Rezoning Transportation Analysis

Petition Number: 2023-002

Date	Description
5-24-23	First Review (IW)
6-13-23	Second Review (DR)
7-25-23	Third Review ZC (IW)

RZ-1

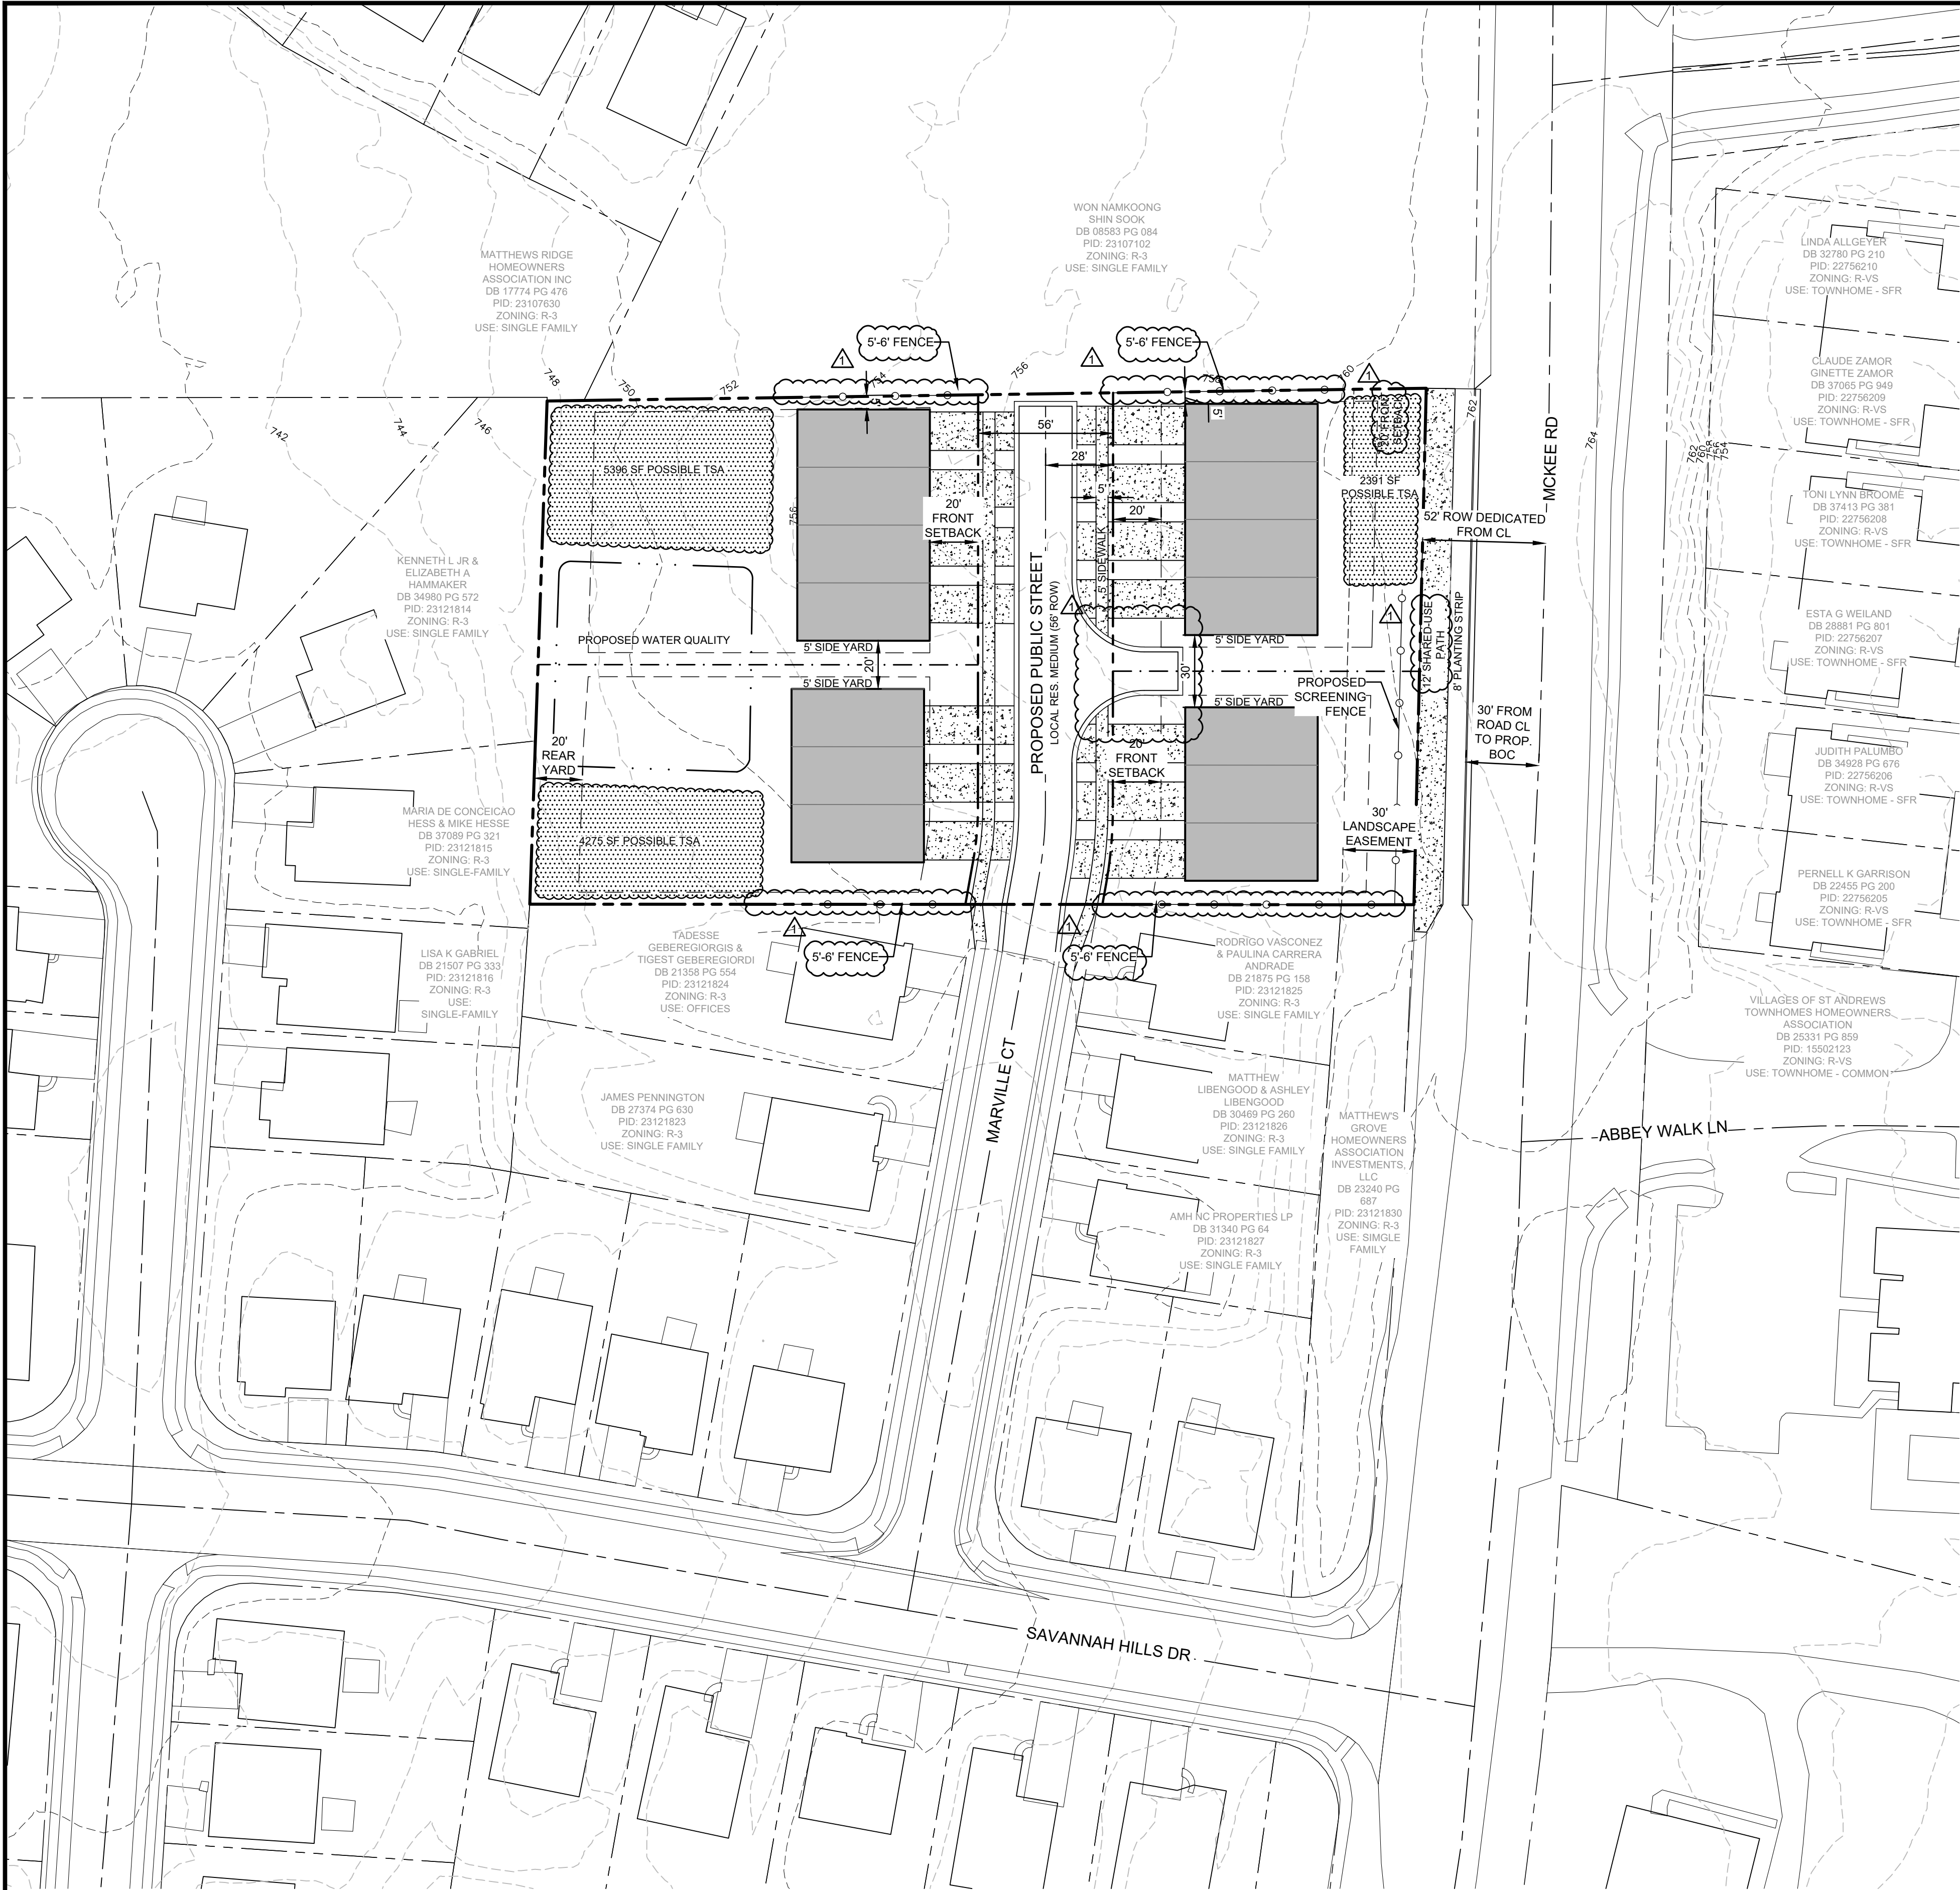
8. **New Comment 07-25-2023:** CDOT is requesting that the petitioner add a conditional note committing to installing a pedestrian sign along Marville CT in an effort to create vehicle awareness of the pedestrian on the street.
